**From:** John Charette <john@charette-design.com>  
**To:** Liv Chase <livchase@yahoo.com>, Tracie Reed <traciereed@dextrouscreative...>  
**CC:** Ann Machado <AMACHADO@portlandmaine.gov>  
**Date:** 8/18/2014 10:13 AM  
**Subject:** Re: 180 Washington Ave - Permit #2014-01749  
**Attachments:** S 1 Structural framing plan.pdf; S 2 Structural framing plan.pdf; S 3 Structural Framing Plan.pdf; A 1.2 Floor Plans.pdf; C 2 Site Plan.pdf

> I have completed my initial zoning review and at this time I can't sign  
> off. I need the following:

A2.2

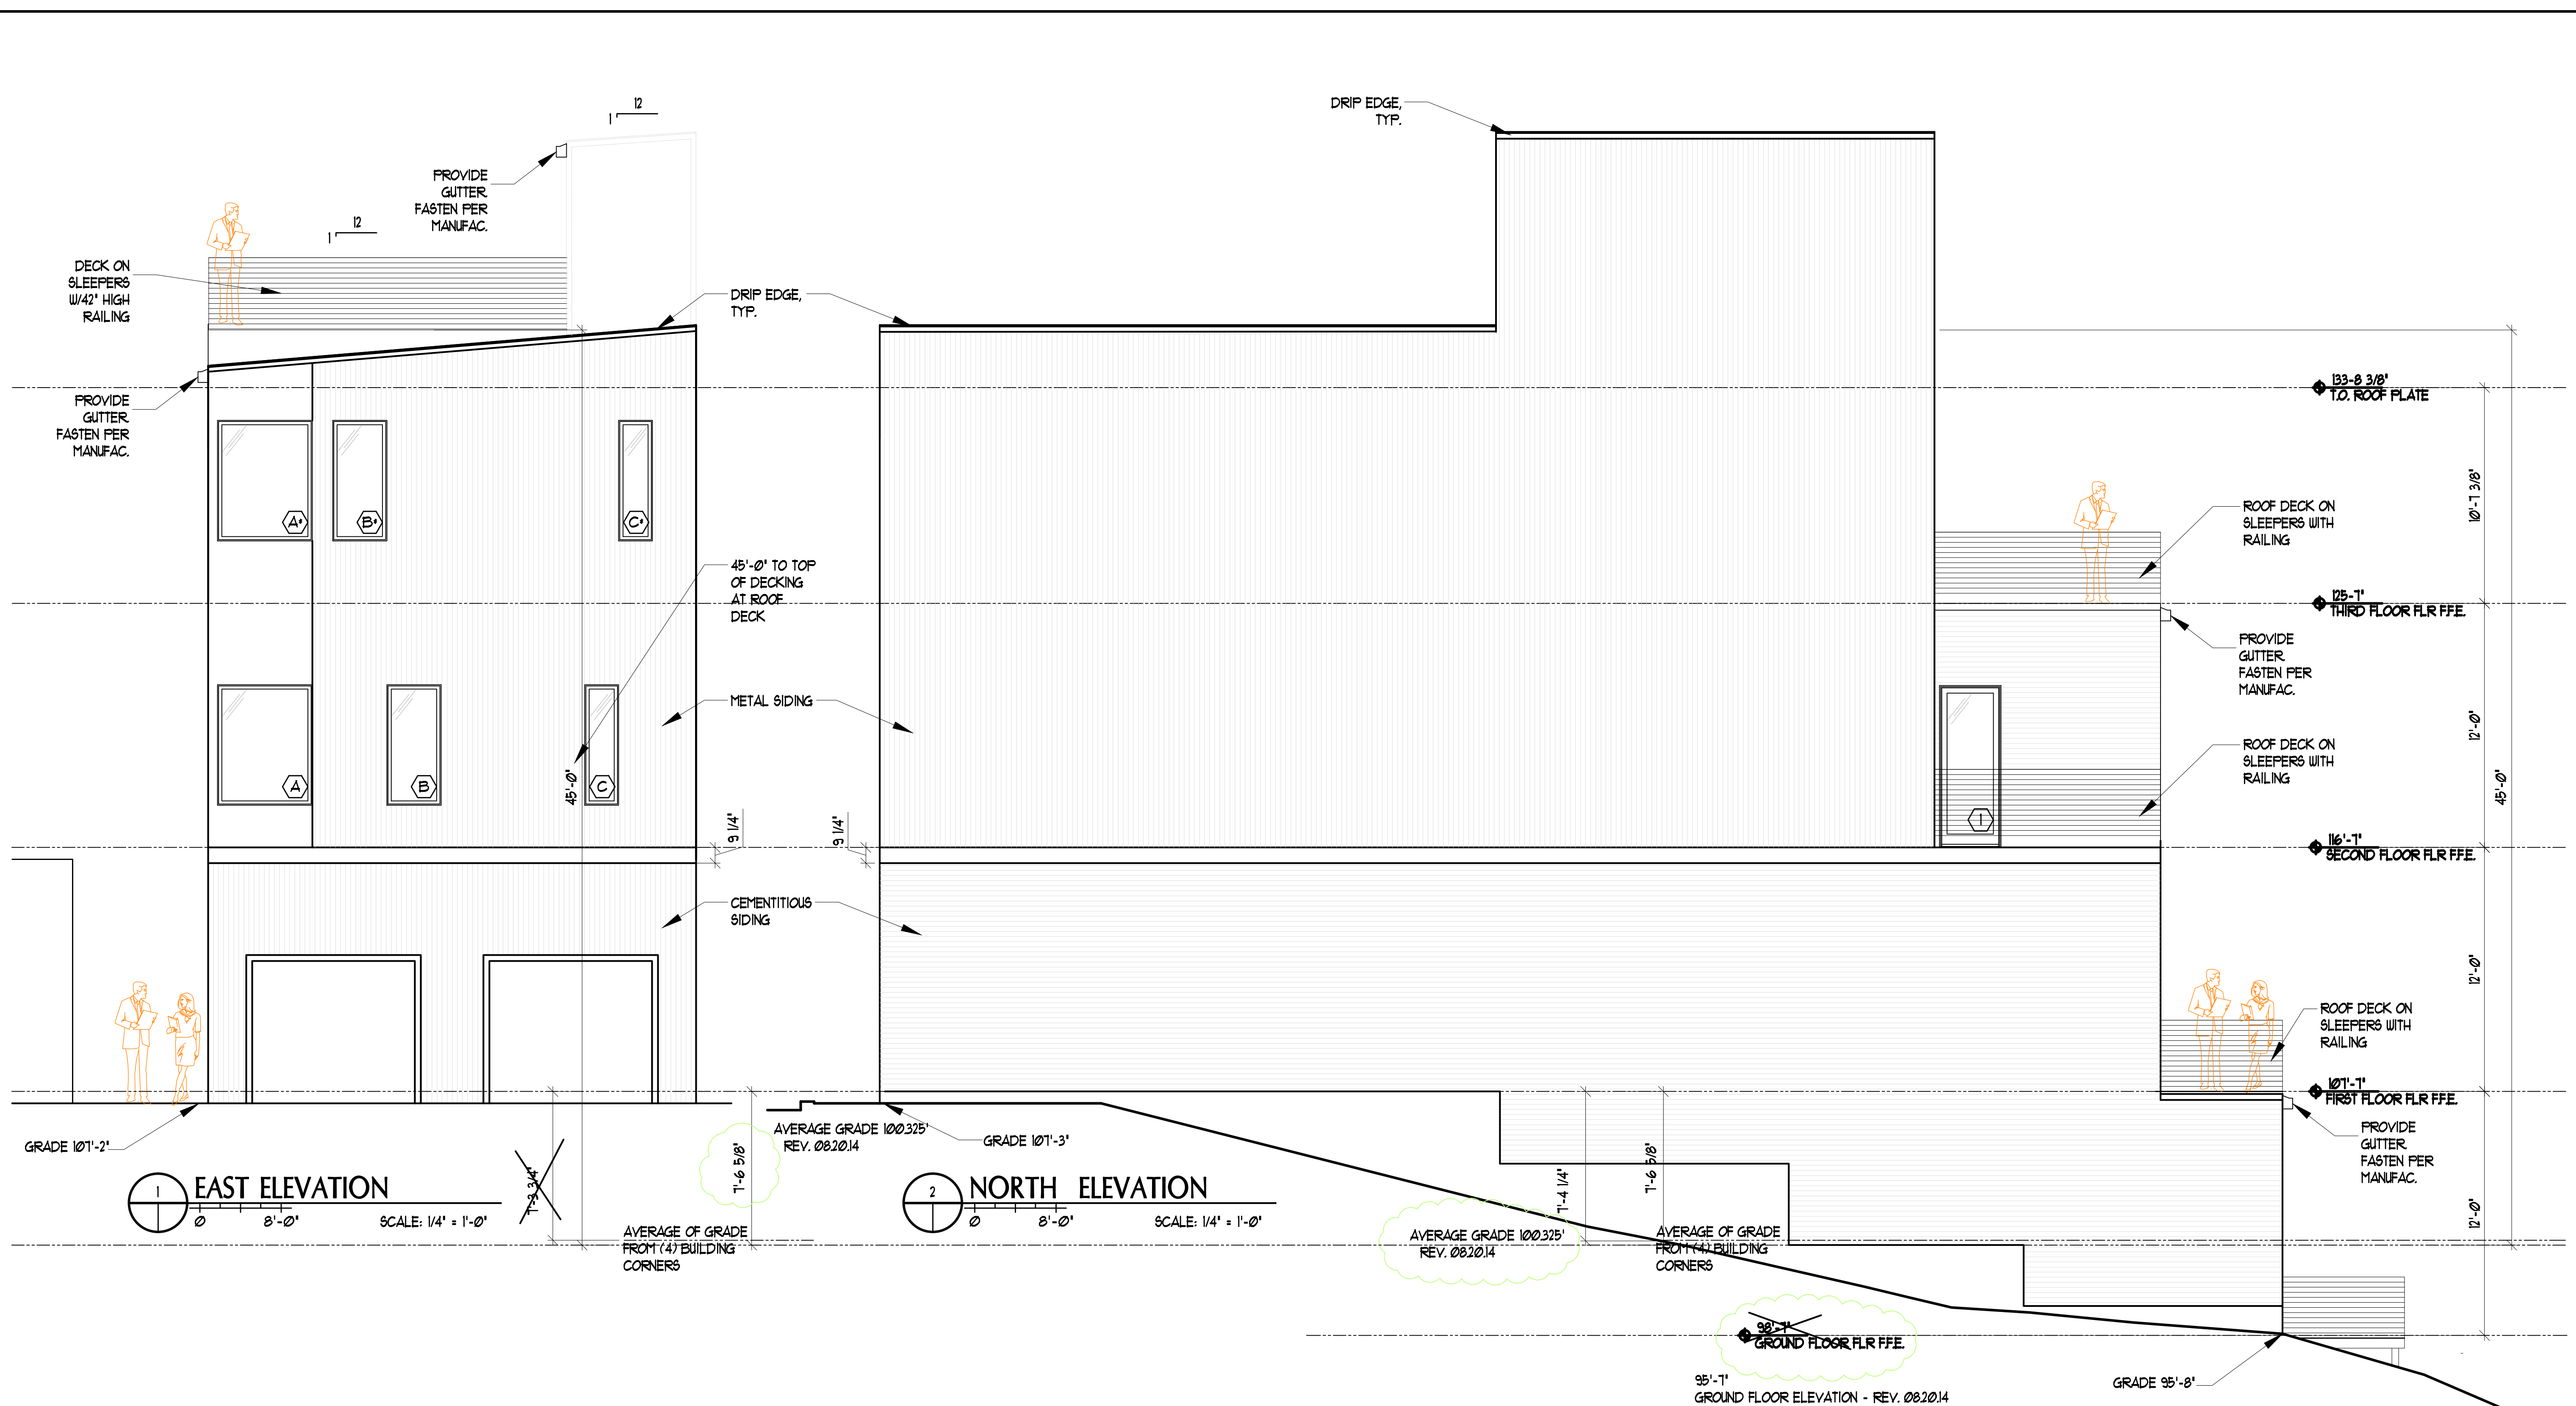
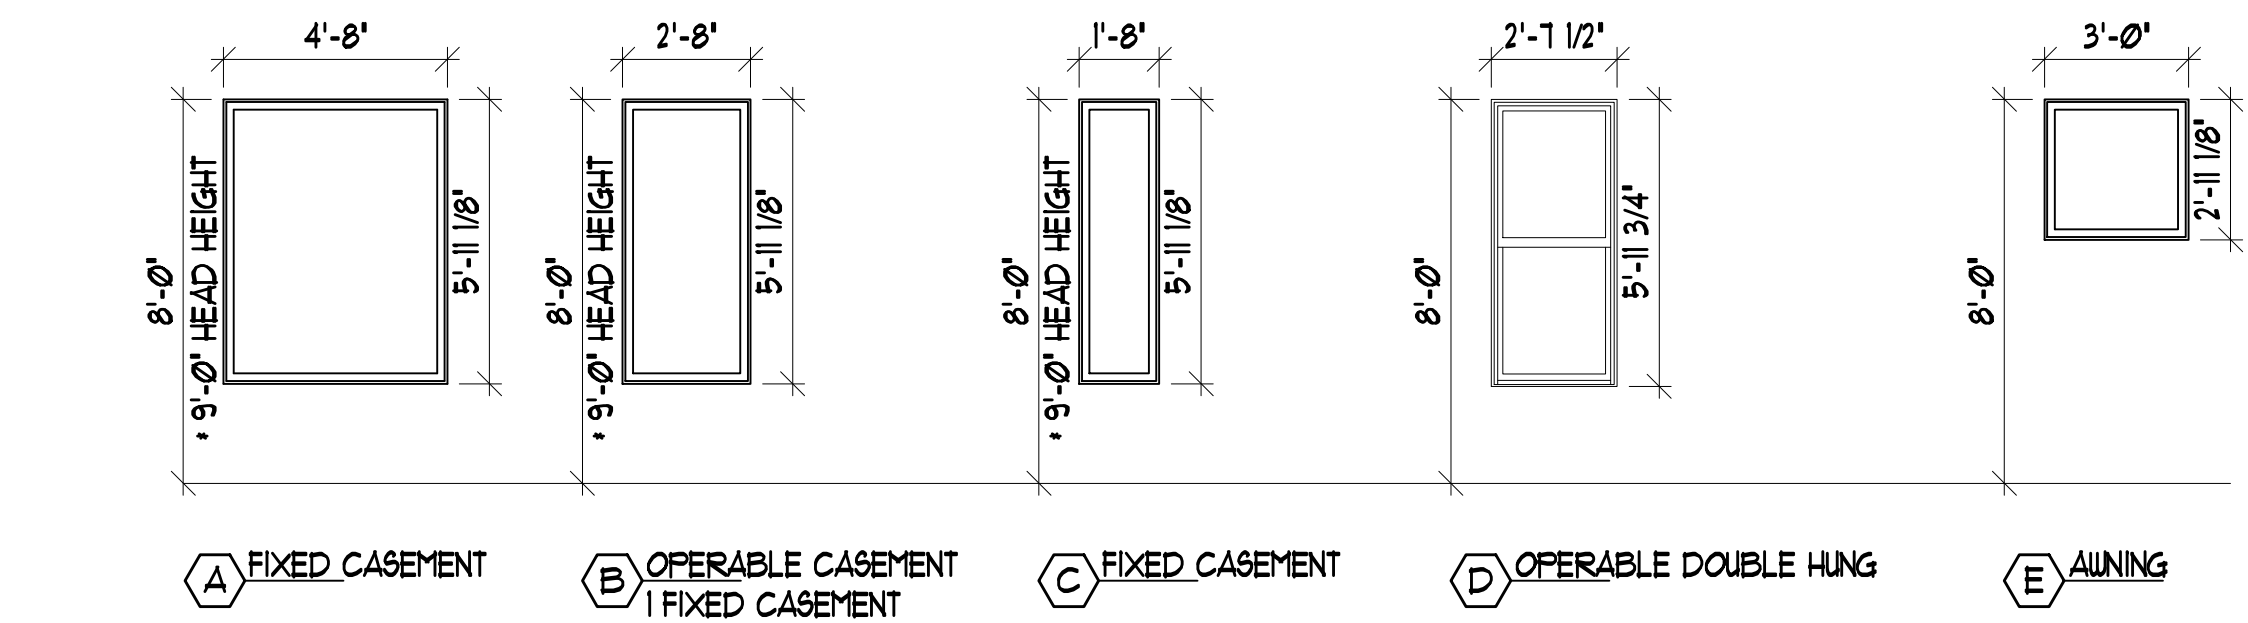
- > 4. There appear to be discrepancies between the floor plans and elevation  
> plans.
    - > -the footprint of the building is 69' x 24'
    - > - the foundation plan and the Ground level plan match these dimensions and  
> what the West elevation shows - the south elevation does not include the  
> deck off the rear of the ground floor

- > - the first floor footprint (A1.2) is 19'8" x 63' with the 6' deck off the  
> back - the West elevation shows the rear as being the full 24' wide - the  
> East elevation shows the front where the garage are as 24' wide - also what  
> are the 5' x 14' extensions off both sides of the building? The building is  
> 24' wide and with 5' extensions coming off both sides the footprint would  
> be 34' wide and the lot is only 29.92' wide - the floor plan also shows a  
> door on the left side which is not on the north elevation.

- > - the second floor footprint is also around 19.7' wide by 63' long - the
- > north and west elevations show a small deck on the right rear corner which

- > is not shown on the floor plan - the north and west elevation also show the
- > building as being 24' wide for the front three quarters of the building,

- > -It is unclear on the East and South elevations if the building is
- > indented on the 2nd & third floors or if it is just different facade
- > material

- > 5. The application states that there are three bedrooms in the second unit
- > but the second floor plan only shows two.
- > 6. The North elevation gives the average grade (based on the average of

- > the four corners) as 45 to the top of the roof. You need to give the
- > elevations at the four corners to show how you came up with the average
- > grade. Also if there is a roof top deck, the height of the building needs

- > to be measured from average grade to the top of the decking on the deck.
- > 7. The site plan does not reflect all parts of the footprint.
- > -The elevations show a 4' overhang over the left side entrance - the

- > building on that side scales at about .66' off the property line - the
- > overhang would encroach over the property line.
- > - Also the concrete barrier block retainer shown on the South and west

- > elevations appear to be 6' wide - which would also encroach on the
- > neighbor's property.
- > - the footprint of the rear deck on the ground floor level is not shown

Please note that the top of decking is (and has been) set at 45' above average grade. The very top of the roof slope is 45' above average grade, and the top of the roof deck sits at this level due to the location on the roof and slope. Sections are correct and elevations are correct with respect to grade and zoning heights, I don't expect revisions but if you need more information we can provide you with whatever you may need.
